Appeal Decision

Appeal Ref: APP/R5510/D/24/3346461

15 Lynhurst Crescent, Hillingdon UB10 9EF

- The appeal is made under section 78 of the Town and Country Planning Act 1990 (as amended) against a refusal to grant planning permission.
- The appeal is made by Mr Saad Awan against the decision of the Council of the London Borough of Hillingdon.
- The application Ref is 17612/APP/2023/3209.
- The development proposed is the erection of a first-floor side extension, rooflight and amendments to fenestration.

PROPOSED ELEVATION
15/LYNH/006.1R

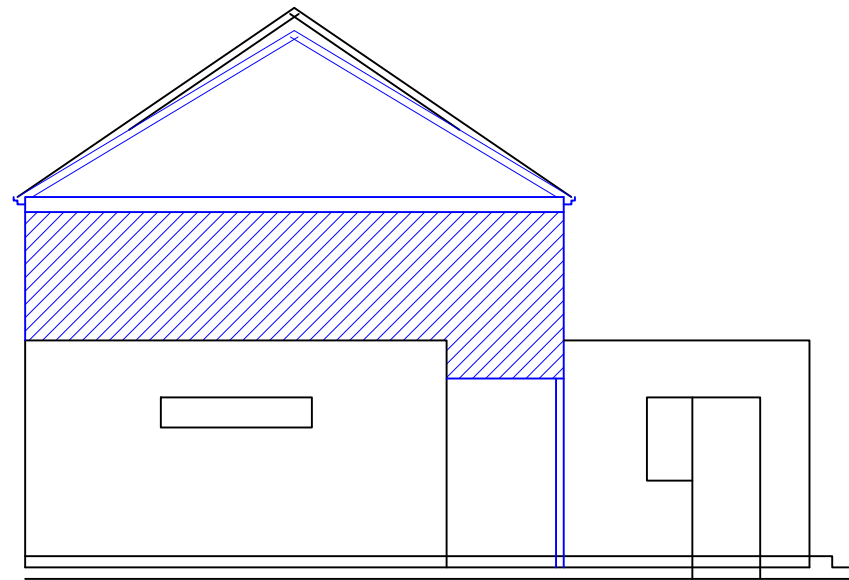
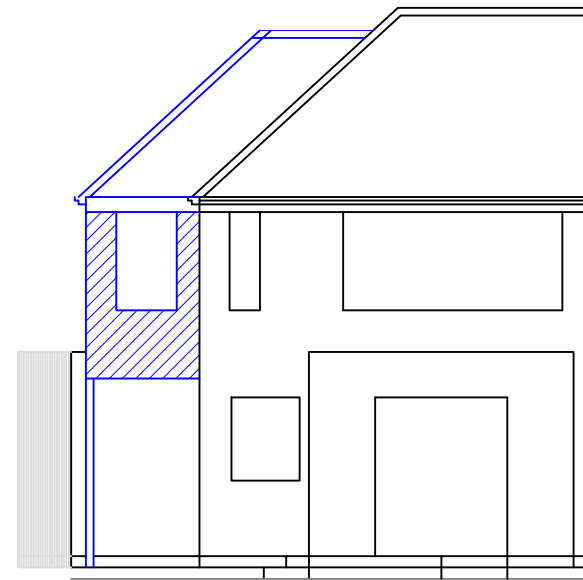
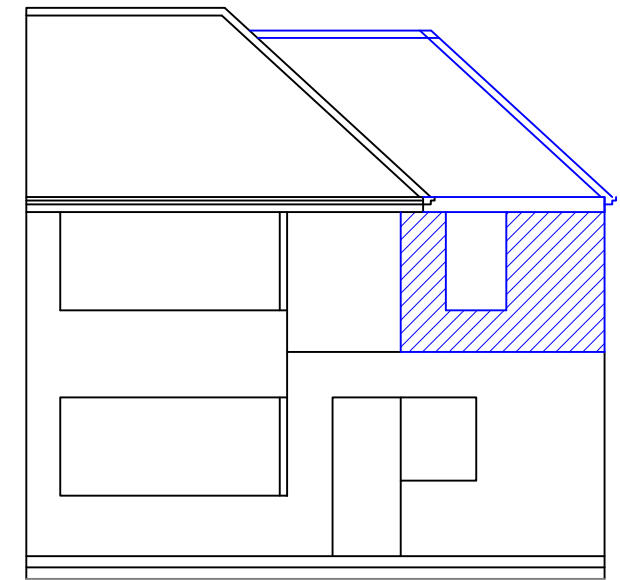
7. The current appeal proposes a pitched, hipped roof with a window in the first-floor front elevation. In principle, this design approach would better reflect the form of No 15 and would improve the appearance of the existing extension, including by reducing its currently somewhat 'boxy' appearance.

8. However, the previous Inspector found that the forward projection of the first-floor front elevation produced an awkward and dominant structure. This element remains in the revised scheme. I agree with the conclusion of the Inspector. Notwithstanding that the extension would remain less than half the width of No 15, there would be no 'step in' from the ground floor side extension, no 'set back' at first floor level or any other measure that would minimise its bulky appearance. The proposed development would not be sufficiently subordinate to the host dwelling.

9. The forward projection would also affect the design and construction of the proposed roof, resulting in an incongruous roof form that would jar with the design of the main roof of No 15 and would harm the appearance of the terrace. It would also contrast unacceptably with the roof of No 17 whilst increasing the visual terracing effect between the two neighbouring houses. The proposal would lead to a cramped appearance within the street scene, notwithstanding the slightly splayed siting difference between the two blocks of terraces.

11. For the reasons set out above and having regard to all other matters raised, I conclude that the proposed extension would harm the character and appearance of the host dwelling by reason of its size, siting and design and would not be sufficiently subordinate. The proposal would result in a cramped and incongruous development which would harm the character and appearance of the wider street scene. For these reasons, the proposed development fails to comply with Policies DMHD1 and DMHB 11 of the Hillingdon Local Plan: Part Two - Development Management Policies (January 2020).
